11 March 2025

**SSD-69257218 at 60 GREAT SOUTHERN ROAD BARGO 2574**

I refer to the Department's email of 11 March 2025 regarding the Environmental Impact Statement (EIS) for State Significant Development SSD-69257218 Mixed-use development with in-fill affordable housing, 25 Moss Vale Road Bomaderry for 'Mixed use development with 196 dwellings, including attached dwellings, six residential flat buildings and shop top housing, commercial tenancies, a boarding house, a childcare centre, a medical centre, at grade parking and public domain works' at 25 Moss Vale Road Bomaderry (Lot 110 DP 131219, Lot 129 DP 3060, Lot 1 DP 520502) in the Shoalhaven City Council local government area (LGA). Submissions need to be made to the Department by 7 April 2025.

SITE LAYOUT PLAN
SCALE 1:600

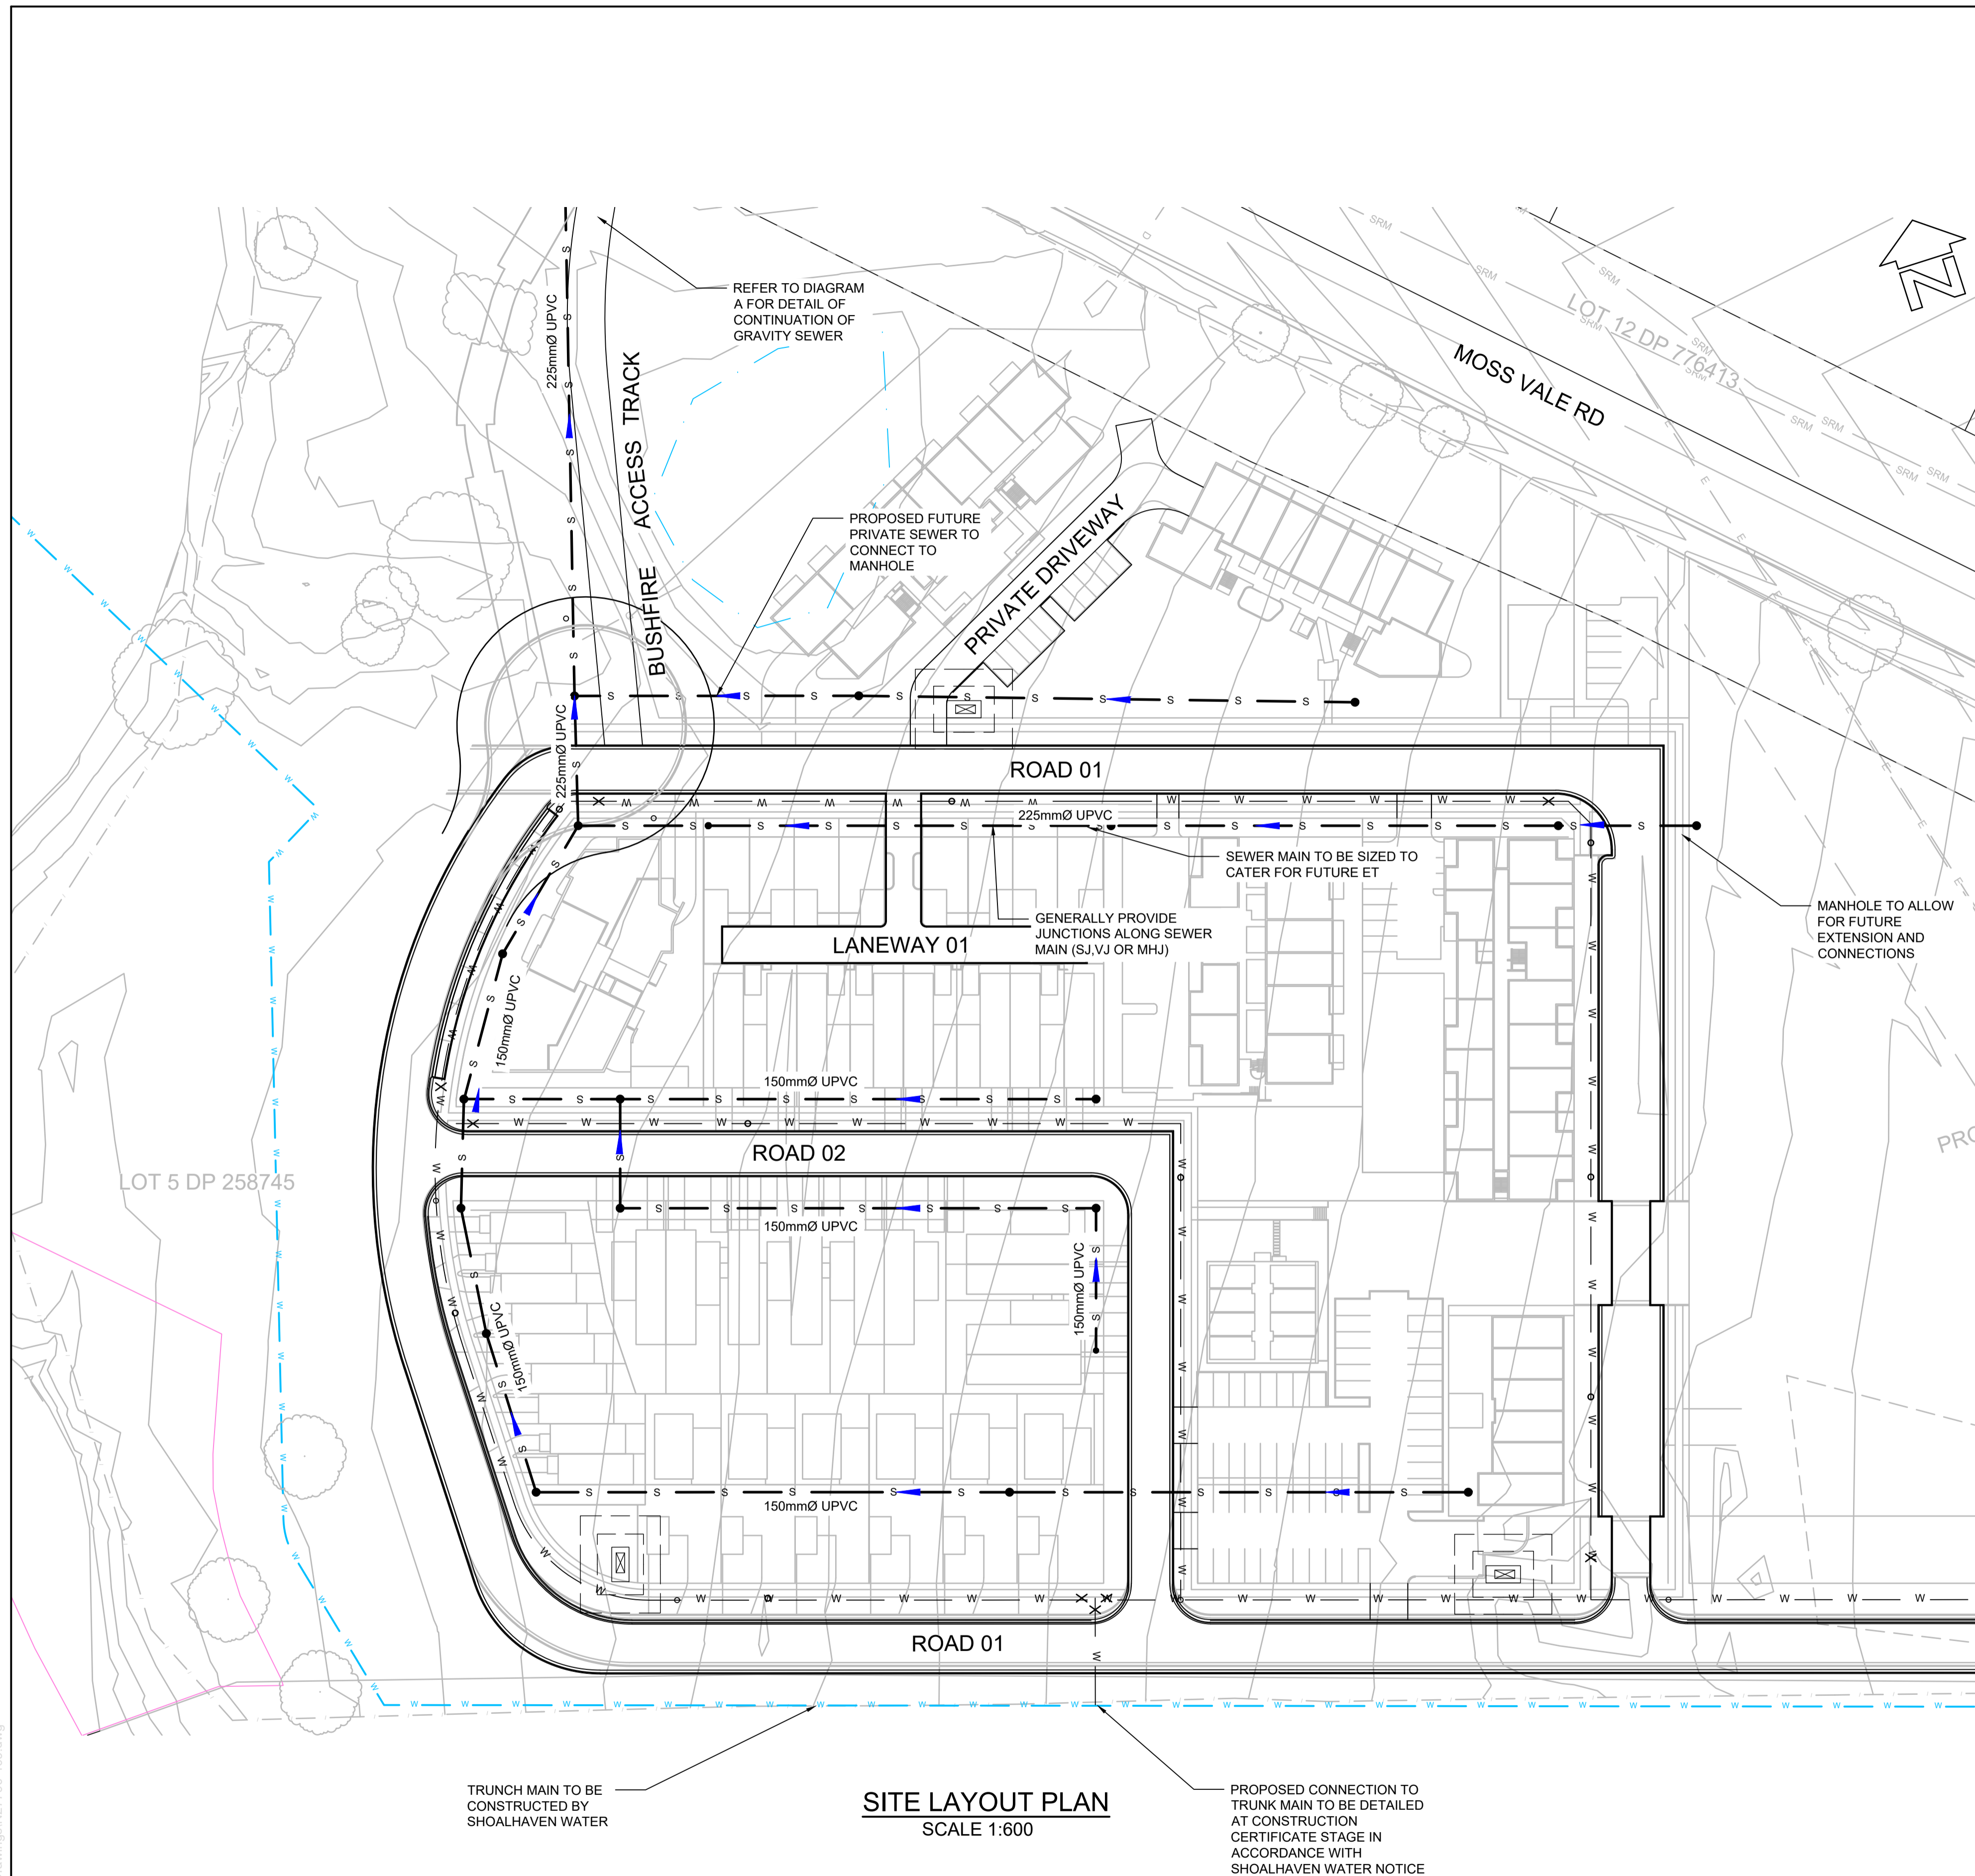
The below copy of the Site Layout Plan shows provision for four padmount substations. Any required padmount substation/s will need to be located within the property (in a suitable and accessible location) and be protected (including any associated cabling not located within a public road / reserve) with an appropriate form of property tenure as detailed in the attached copy of Endeavour Energy's 'Land Interest Guidelines for Network Connection'.

Generally it is the Level 3 Accredited Service Provider's (ASP) responsibility (engaged by the developer) to make sure substation location and design complies with Endeavour Energy's standards the suitability of access, safety clearances, fire ratings, flooding etc. If the substation does not comply with Endeavour Energy's standards, the applicant must request a dispensation.

EASEMENT PLAN
1:1000

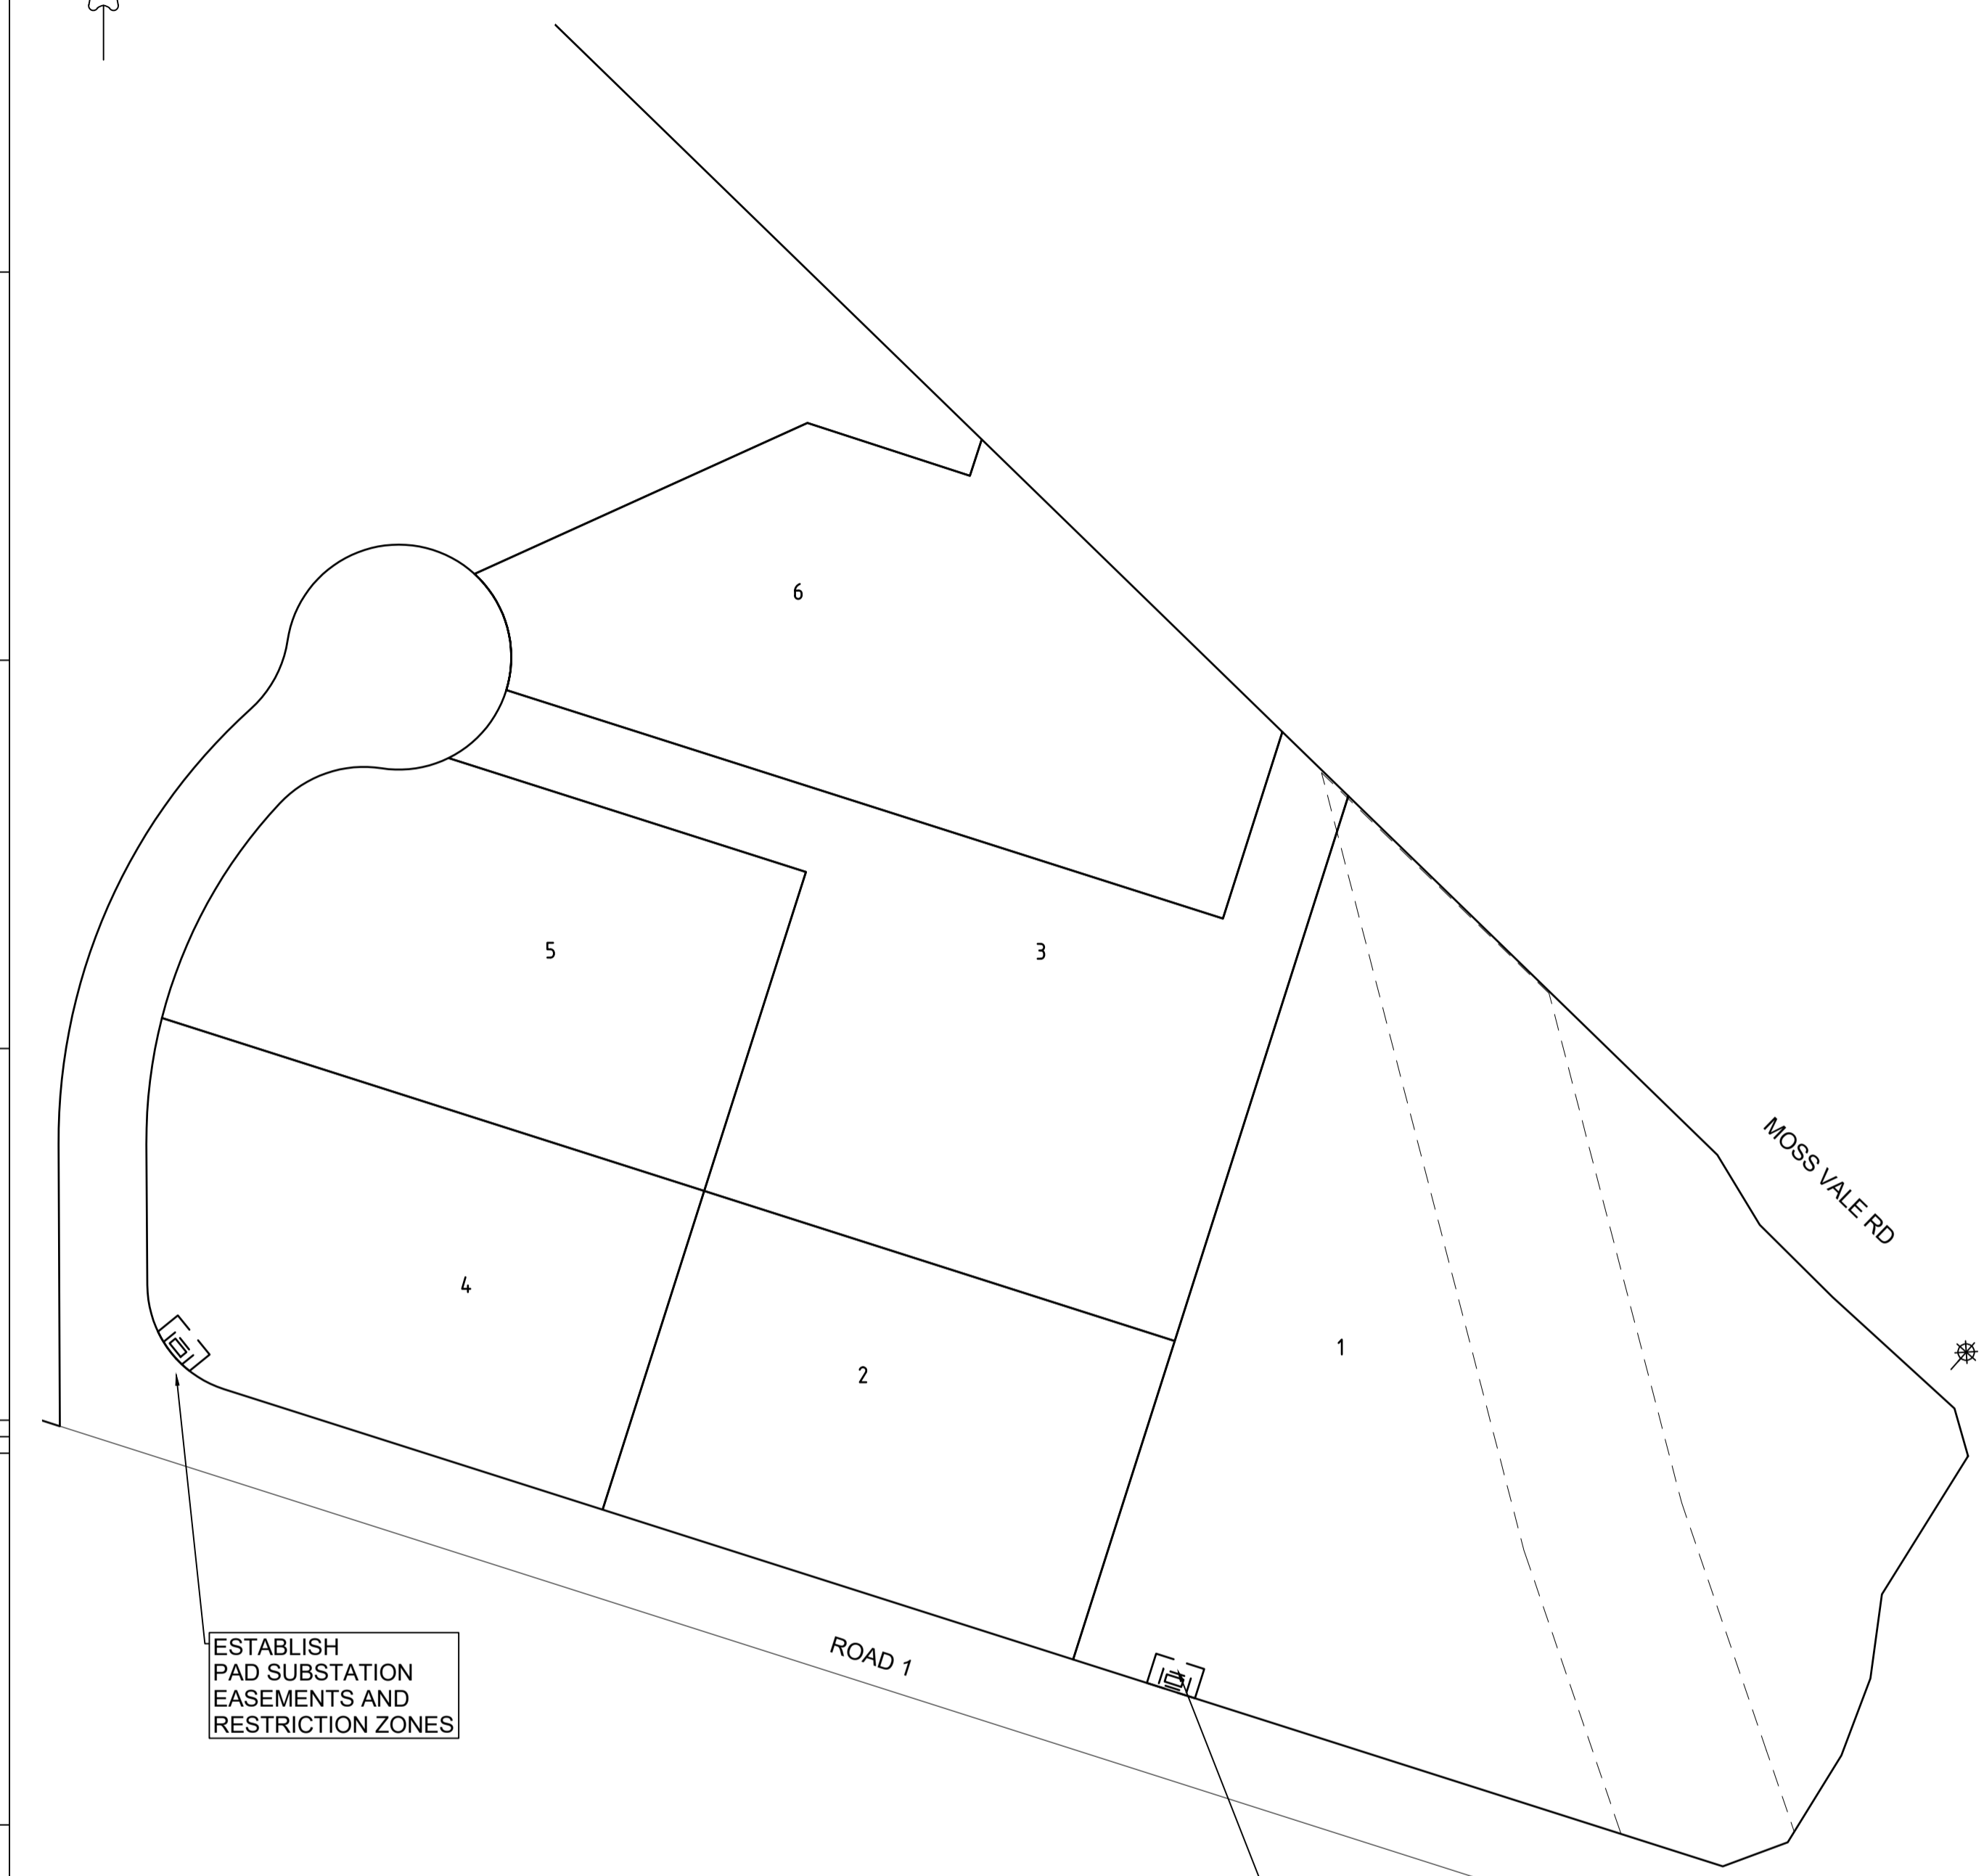
The EIS mentions but does not appear to address in detail the easement for 33,000 volt / 33 kilovolt (kV) overhead transmission lines. The Master Plan shows the proposed subdivision of part of the easement which is opposed by Endeavour Energy ie. as per SF10851 the easement should be entirely within proposed Lot 1 – but which appears may be rectified by the 'Building Setback for Possible Future Road Widening'. There does not appear to be any evidence of any consultation / approval from Endeavour Energy's Easements Officers.
